Application No: EP/124/20/HH
Site Address: Little Dormers 23 Upper Drive East Preston BN16 1QN
Description of works: New bay and porch skirt roof to the front elevation, and roof linked detached double garage.

Thank you for your internet representation made on 30th November 2020 which has been recorded as an objection with the comments as follows:

Garage Plans and Elevations -
Proposed

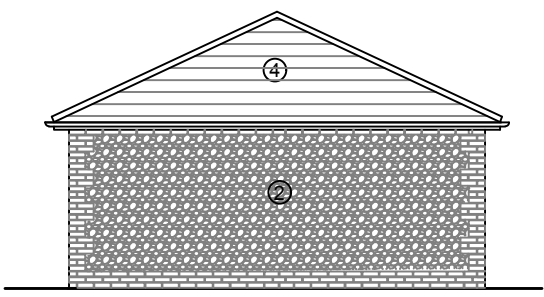
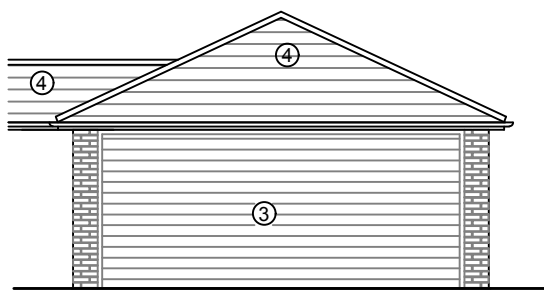
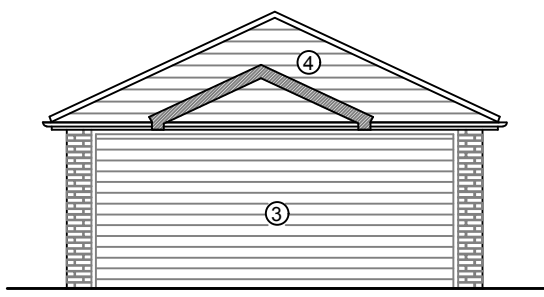
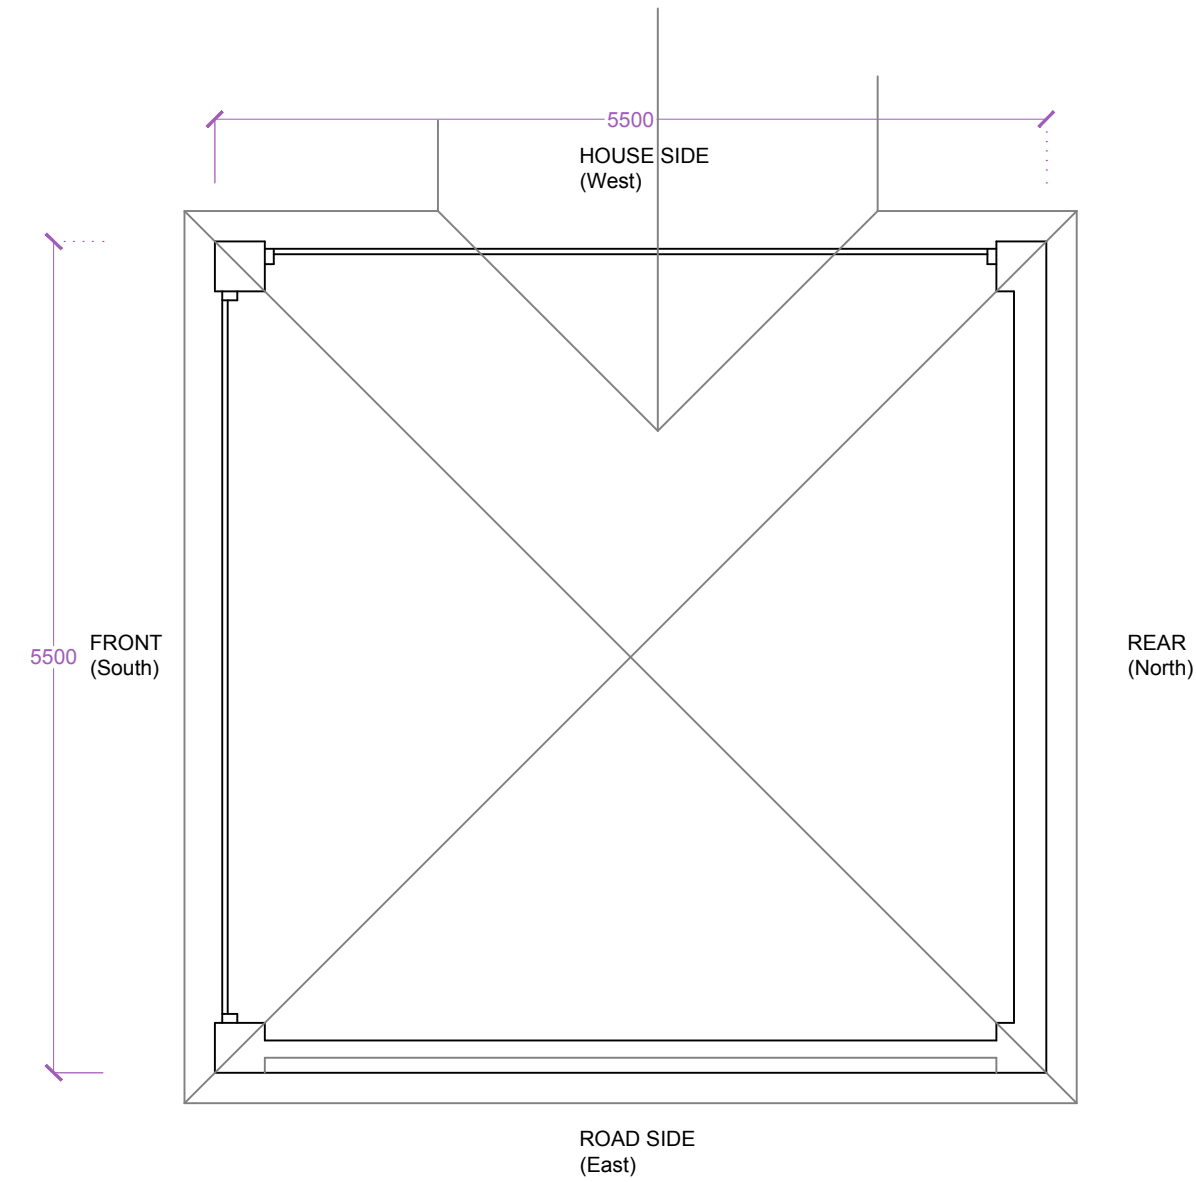
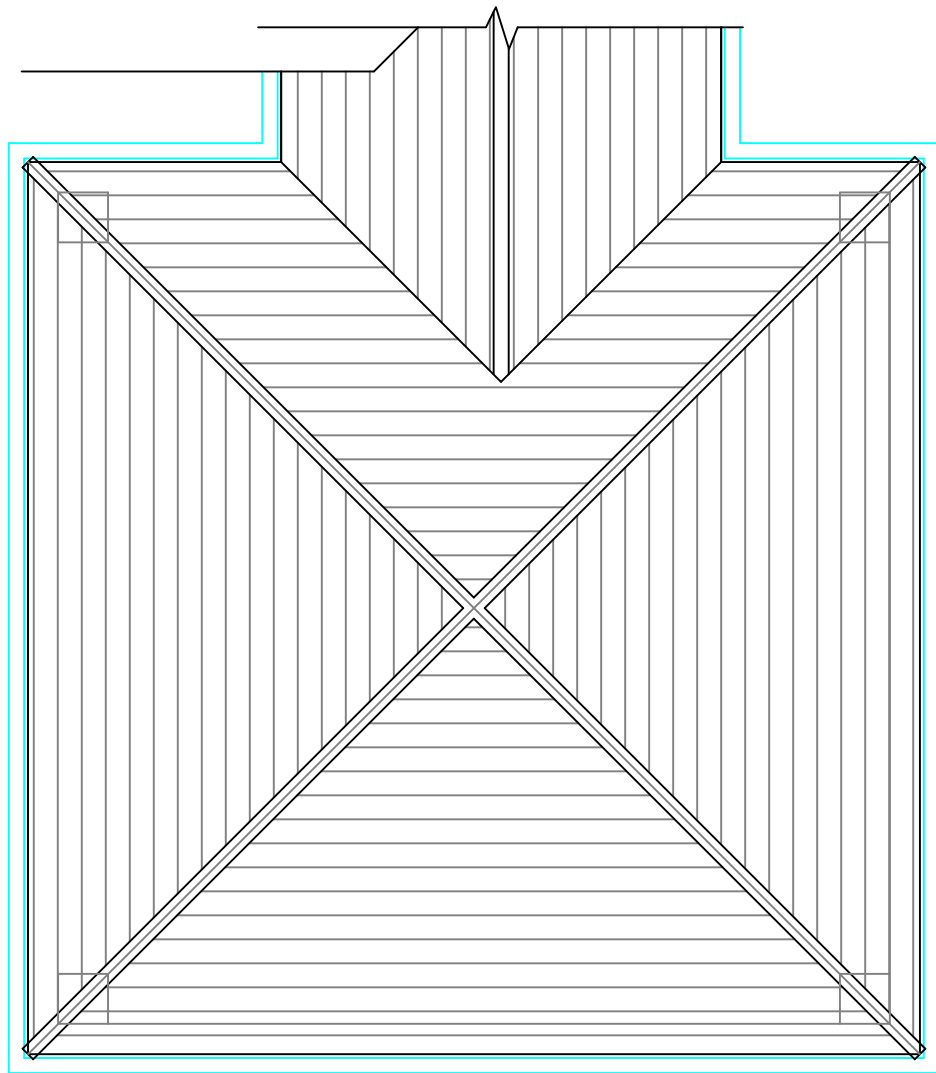
The construction of this Garage and what looks like a Ranch style veranda across the building will completely change the look of this home and will not enhance it at all.

the construction will change the street scene making the street feel very different in character and closing down the open feel to these properties.

the garage will have a detrimental affect on the adjoining property cutting out sunlight to the front of No 25.

If the building was to go ahead it would be better being placed on the south side of the property.
